Royal Randwick Racecourse submission to Preferred Infrastructure Report Appendix 1

The following is the ATC's response and commentary to the Submissions Report. For clarity, ATC's proposed conditions of approval have been inserted into the proponent's revised environmental management measures for the CSLER Proposal (Table 8.1) contained in the Preferred Infrastructure Report (PIR).

Extract from Table C.4 - Australian Turf Club (ATC)

Figure 3 – ATC alternative design solution for Gate 1 access and new bus layover area (outlined in **RED**) with buses travelling from PIR revised local access arrangements (outlined in **BLUE**) (Source ATC)

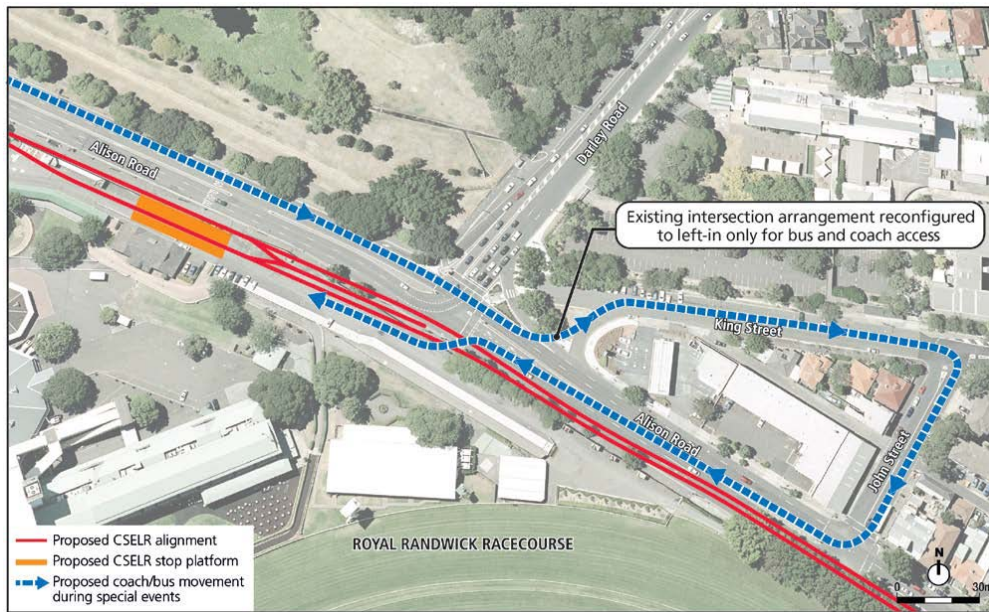
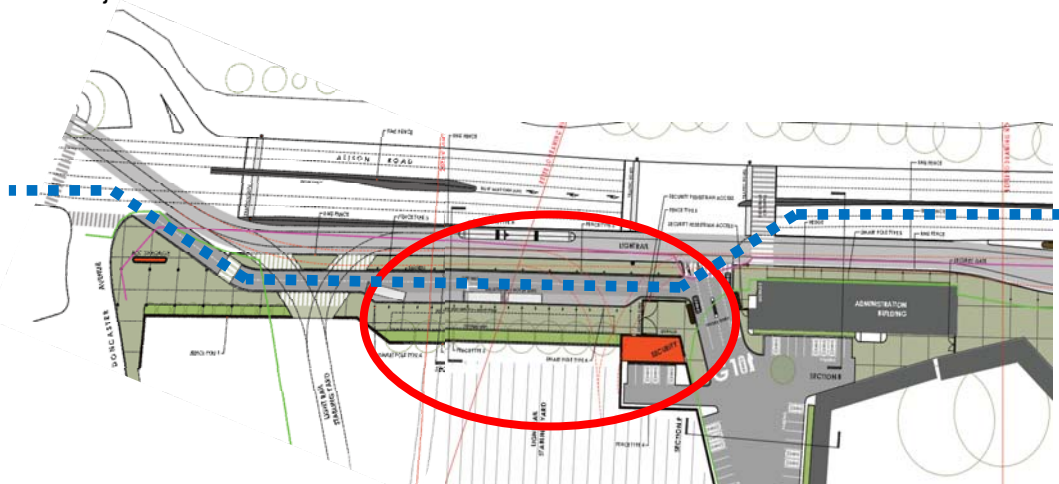
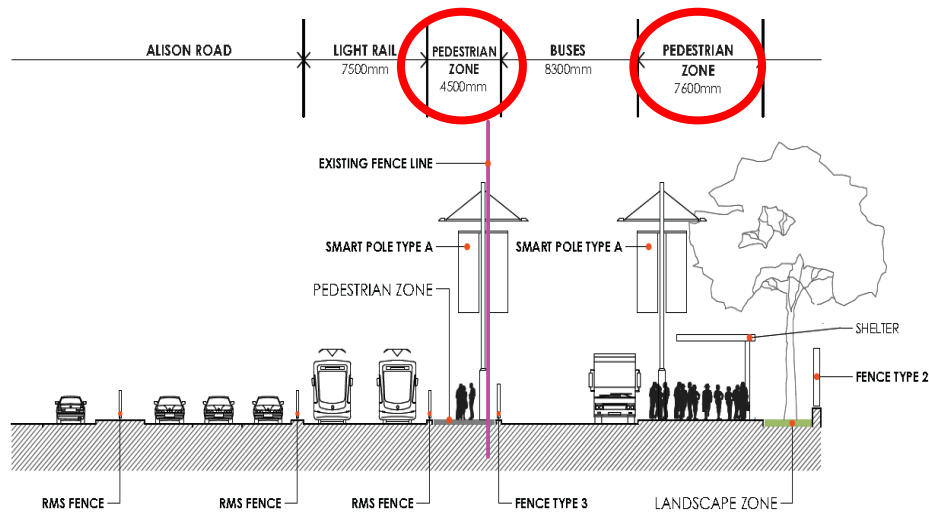
<p>2.2.1</p>	<p>Site uses – non-race day events</p> <p>Submits that reconfiguration of any intersection as a result of the proposal will need to provide for existing access arrangements and potentially supplement existing capacity in the event of capacity loss elsewhere.</p>	<p>Since publication of the EIS, Transport for NSW has further considered access arrangements for Royal Randwick racecourse in consultation with ATC (refer section 6.10 of this report).</p> <p>Following discussions with ATC as part of the exhibition of the EIS, it was identified that eastbound access to the Royal Randwick racecourse from Alison Road for event buses and coaches would be required. To accommodate this requirement, the refined design would provide a slightly reconfigured intersection of the Alison Road and Darley Road intersection to accommodate a new eastbound, bus-only slip lane from Alison Road onto King Street. Buses and coaches accessing the Royal Randwick racecourse would then travel in a loop along King Street and John Street and access the racecourse in a westbound direction from Alison Road. The slip lane would be marked and sign-posted as bus-only to restrict use by general traffic. The proposed changes are detailed in section 6.10 of this report.</p> <p>Bus drop-off and pick-up arrangements would be from Alison Road, to the east of the Royal Randwick racecourse stop.</p> <p>Detailed consideration of access arrangements would be undertaken during detailed design, with regard to ATC's operational requirements.</p>	<p>The ATC does not agree with this response.</p> <p>This design solution does not resolve the issues raised by the ATC.</p> <p>Section 6.10 shows buses crossing over the light rail tracks and into a pedestrian zone adjacent to the RRR Stop. The ATC understands that this may be in error yet the permanent solution has not been advised and is a key safety concern for the ATC.</p> <p>Bus drop off and pick up has not been detailed or modeled sufficiently to ensure safety is maintained for the general public and patrons to the RRR.</p> <p>The ATC recommends an alternative bus layover area as detailed in Figure 3 of this submission (proposed new condition A.32).</p>
